Our Ref:239848
Department Ref: SSD-9827

**RE: PART LOT 4 DP 1238761
45 HONEYSUCKLE DRIVE, NEWCASTLE.**

Thank you for your letter dated 21 February 2020 providing the Departments request for additional information in relation to the above application following further assessment. Please accept this submission as our formal response to the matters raised.

JUNE 21 - shadow casting extent
10 AM

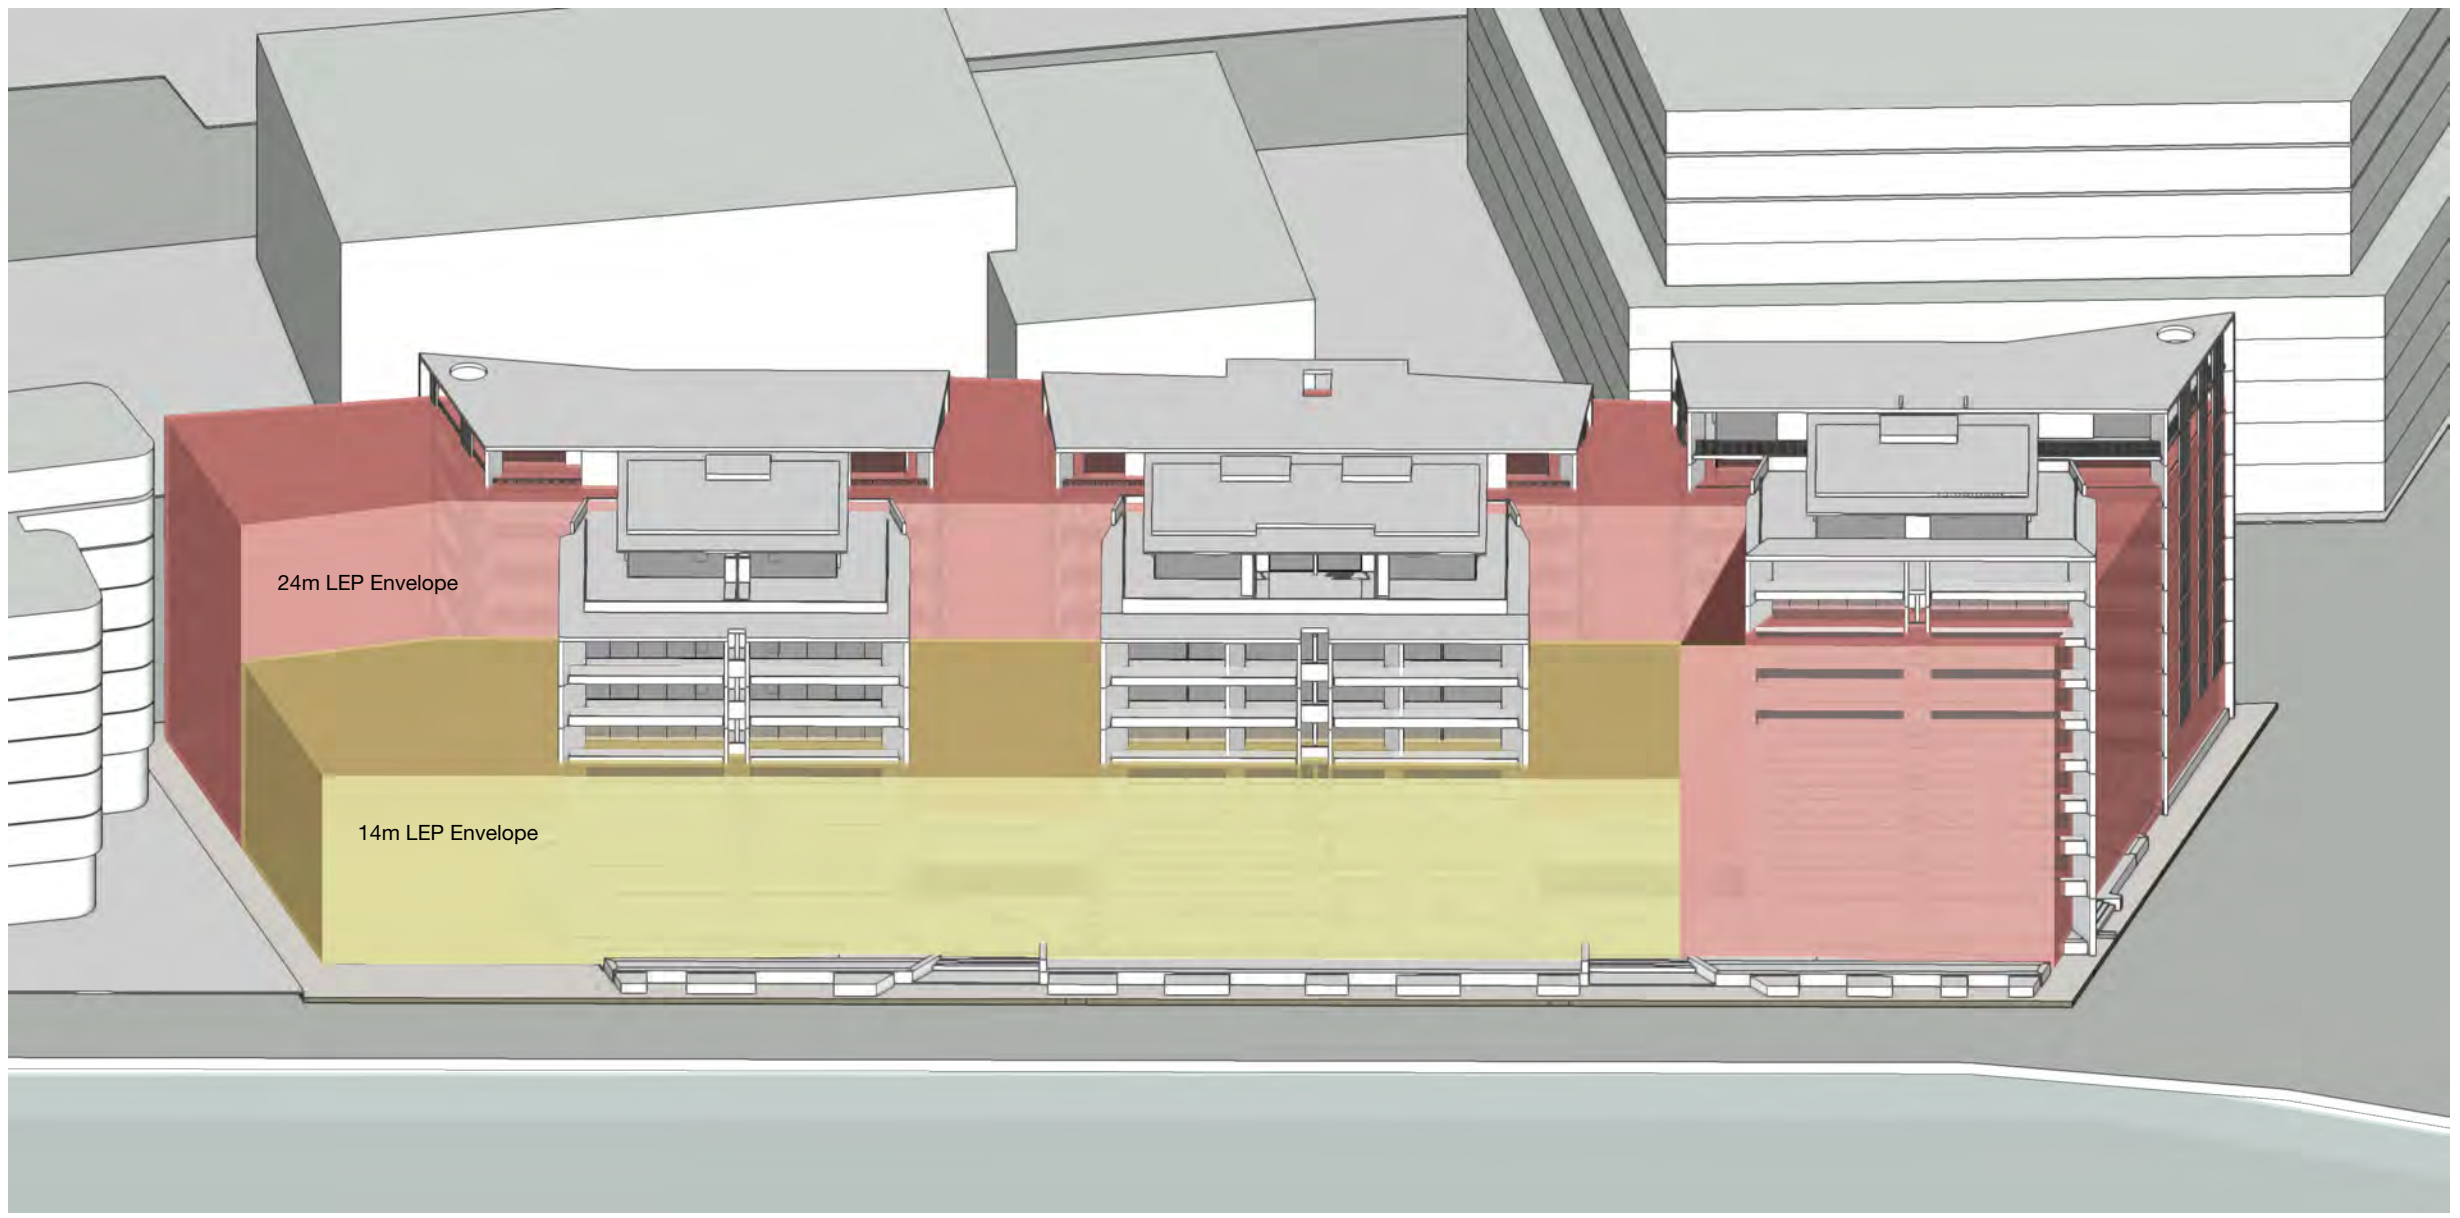
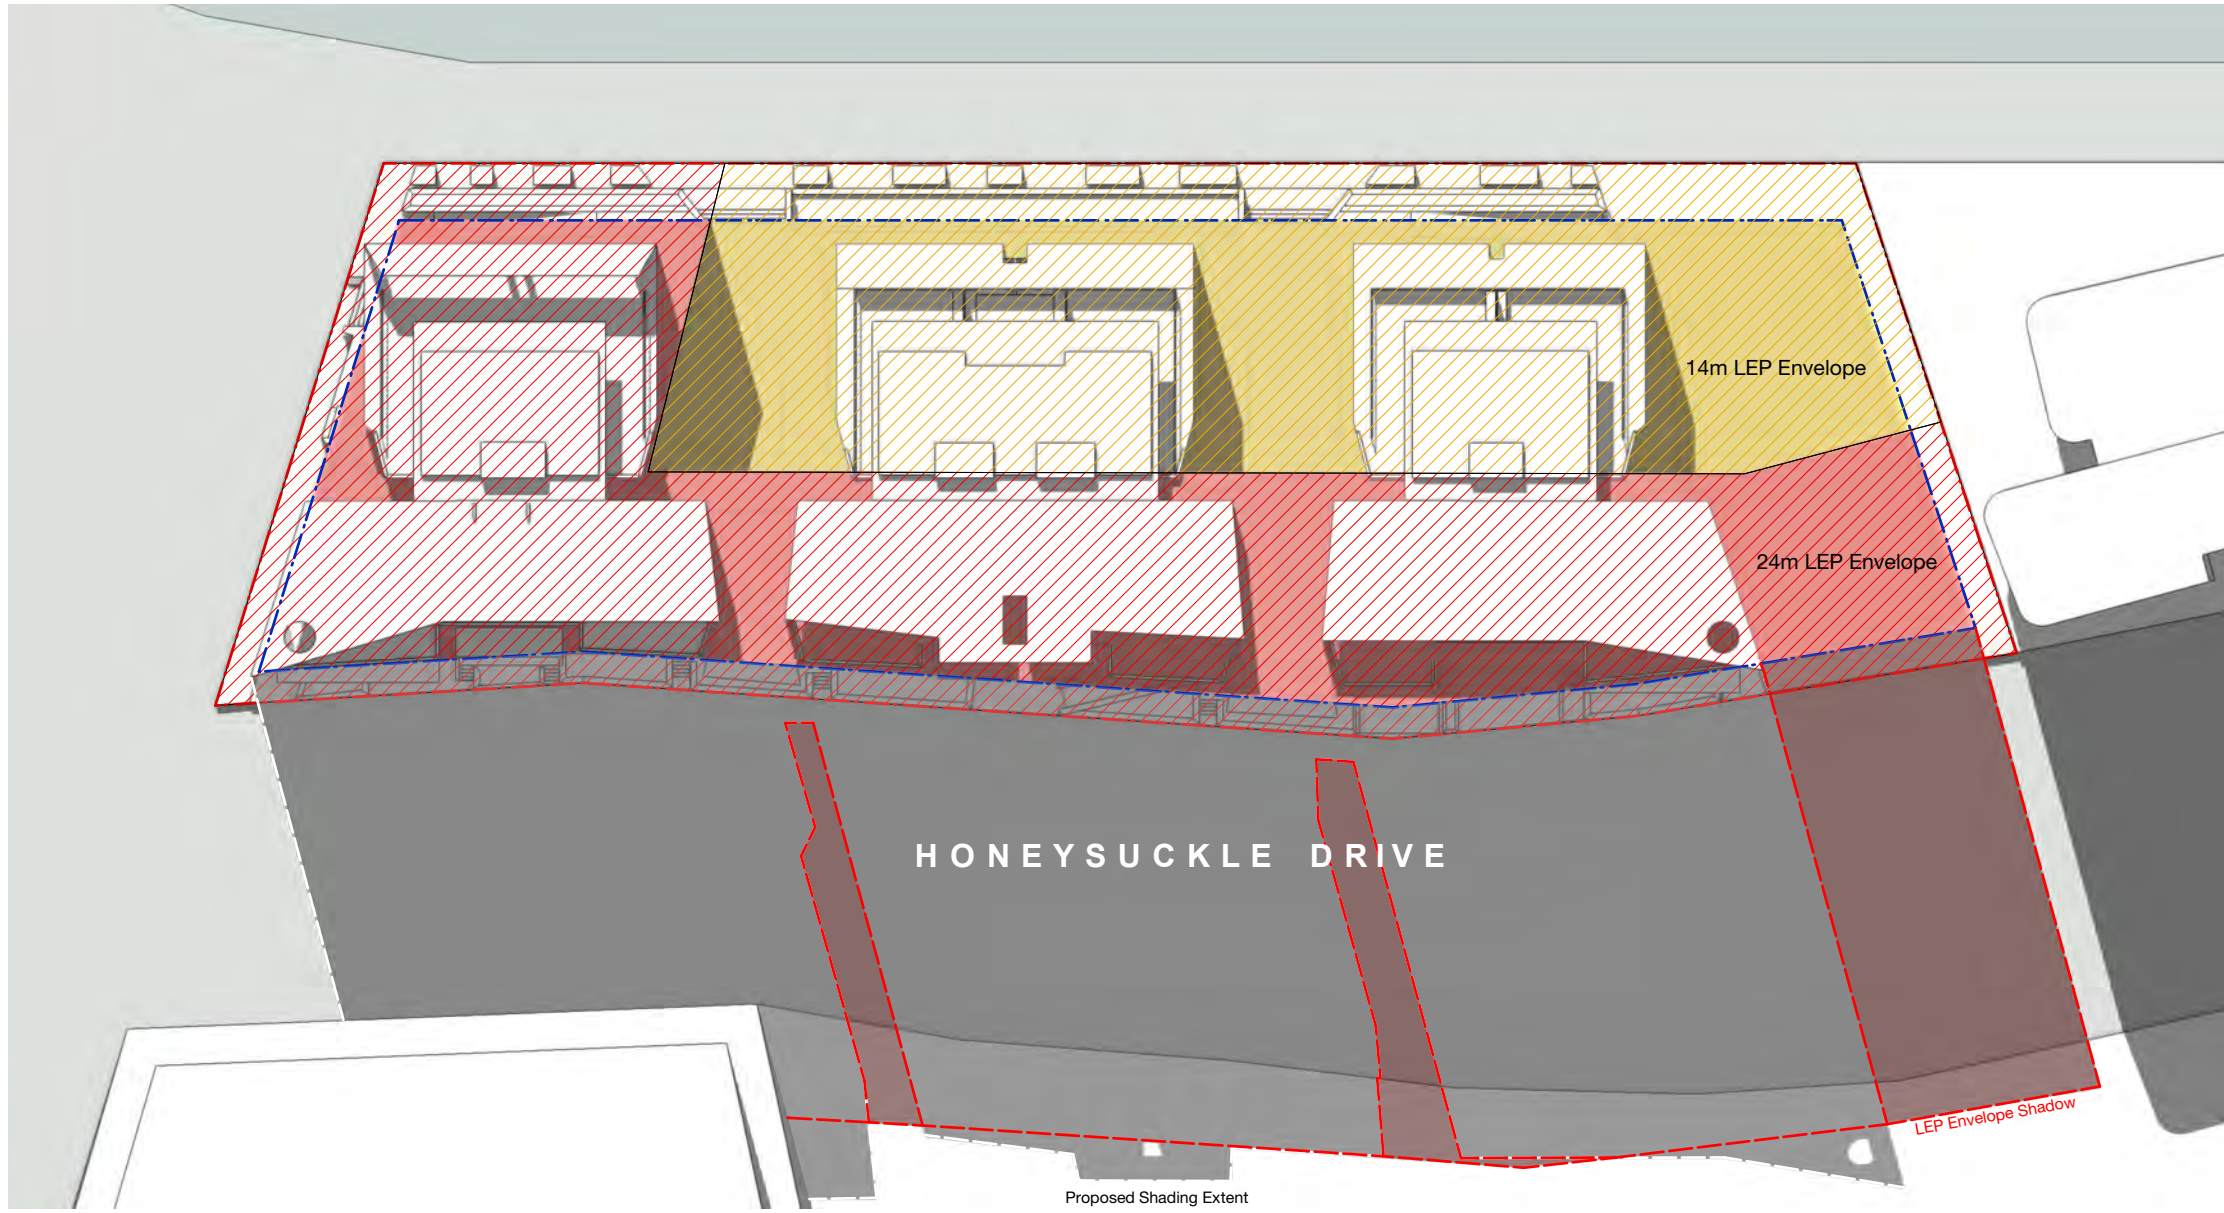
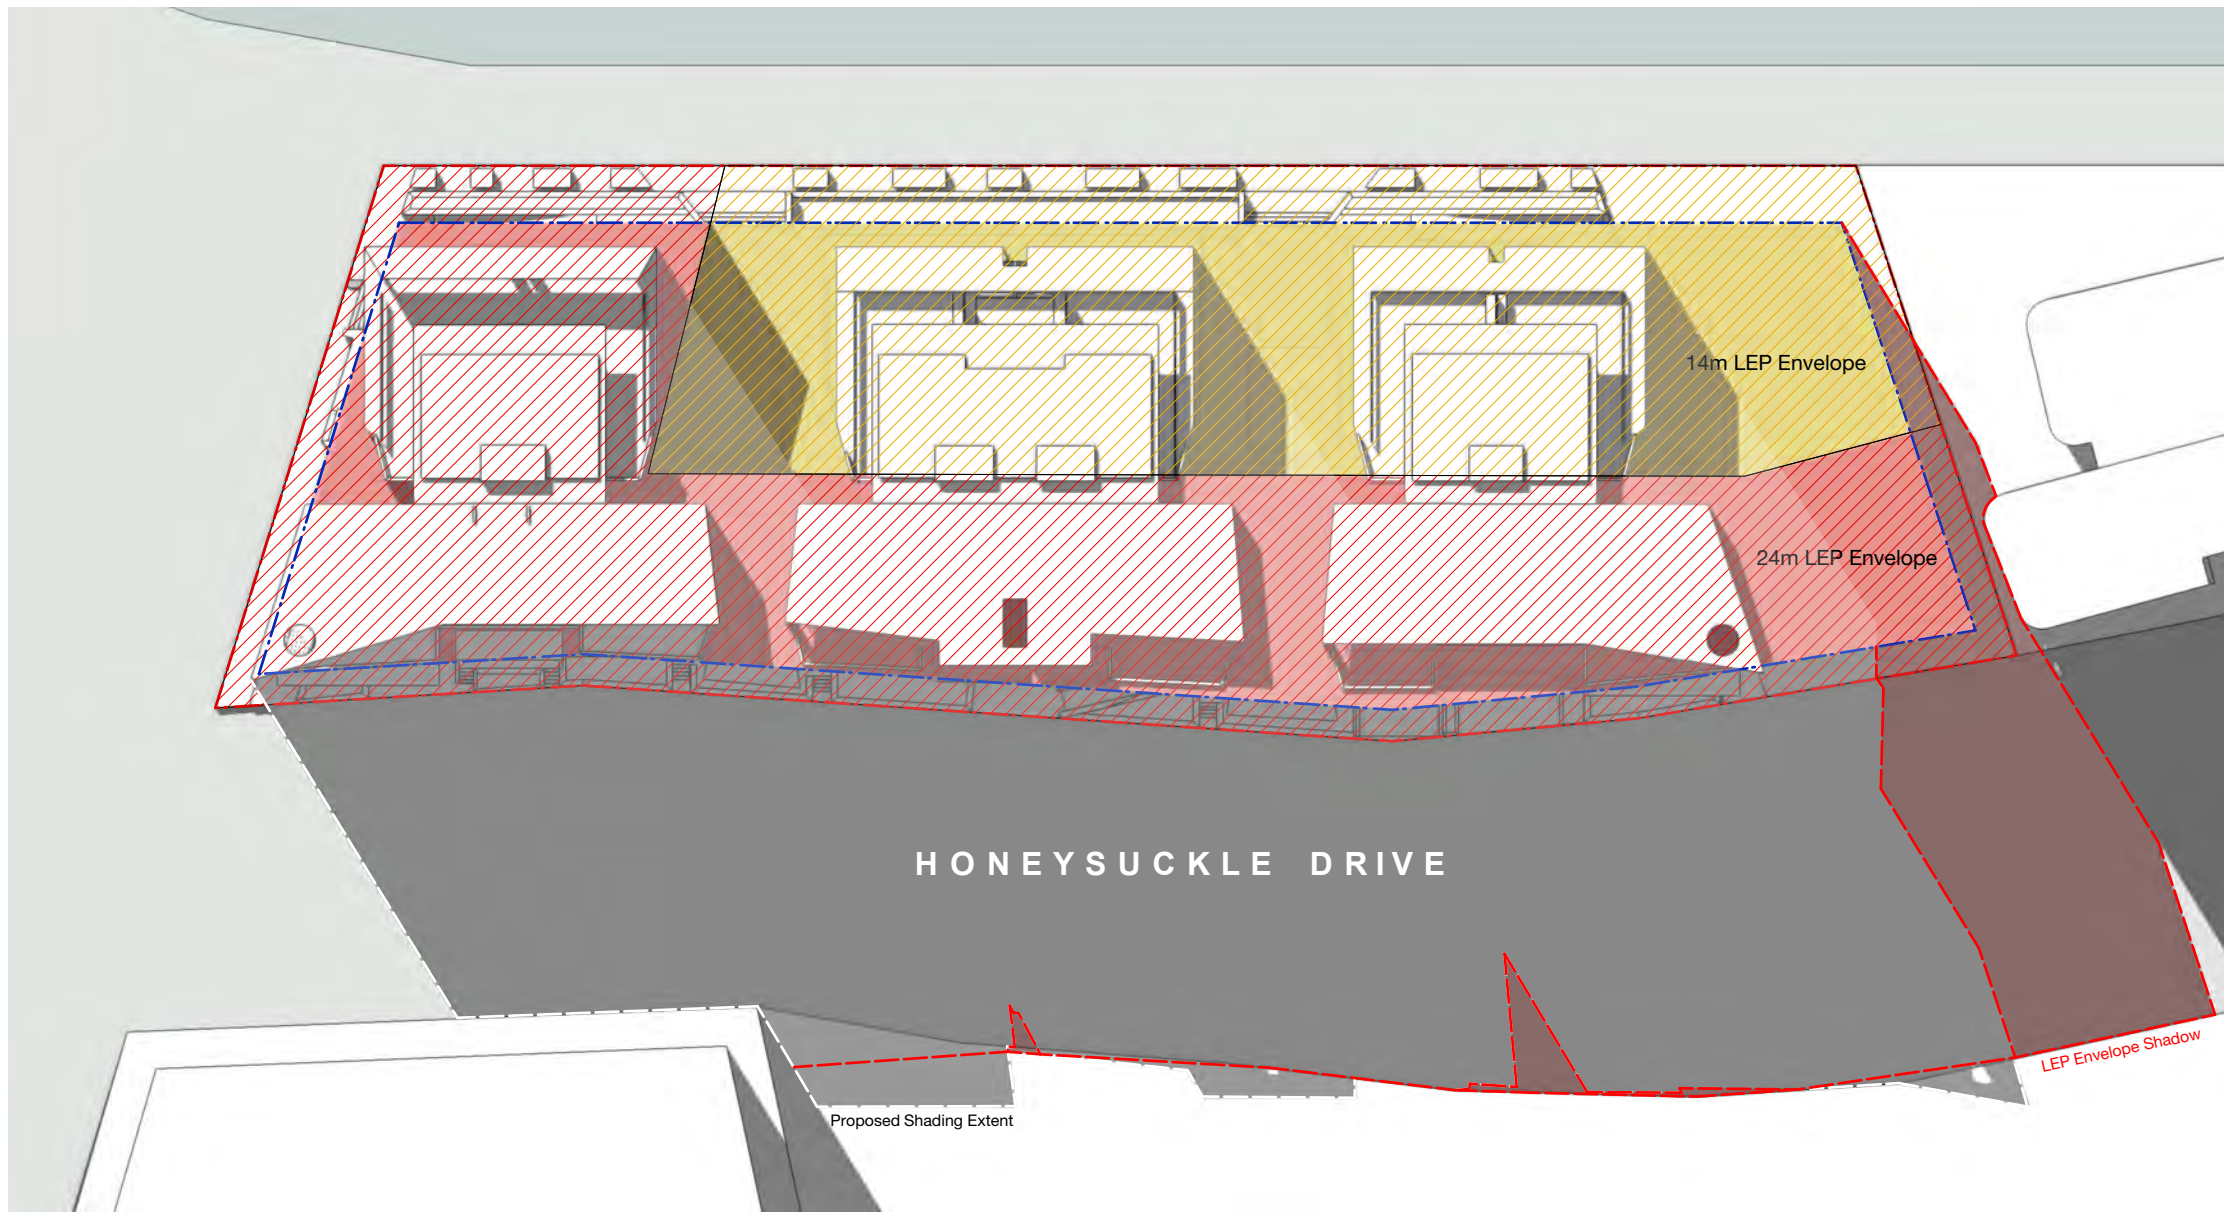
Provide an assessment of view loss impacts, using Tenacity Principles, to the residential apartments and hotel rooms of the approved development at 42 Honeysuckle Drive. The assessment should consider the current proposal as well as an LEP compliant scheme.

A typical built outcome on 45 Honeysuckle Drive would be one assumed to comply with the relevant planning provisions. In this regard, it is considered that a compliant development outcome would see the entire footprint of the site developed up the maximum height would have a greater impact on views from 42 Honeysuckle Drive than what is currently proposed.

However, because the proposed development footprint has been reduced and because a more slender built form with separation between the three (3) buildings the retained views from 42 Honeysuckle Drive are improved. Views from 42 Honeysuckle Drive will be available through the site and via the available space along the Cottage Creek corridor as shown on the below photomontage, which outlines a compliant scheme (in block form) and the proposed development.
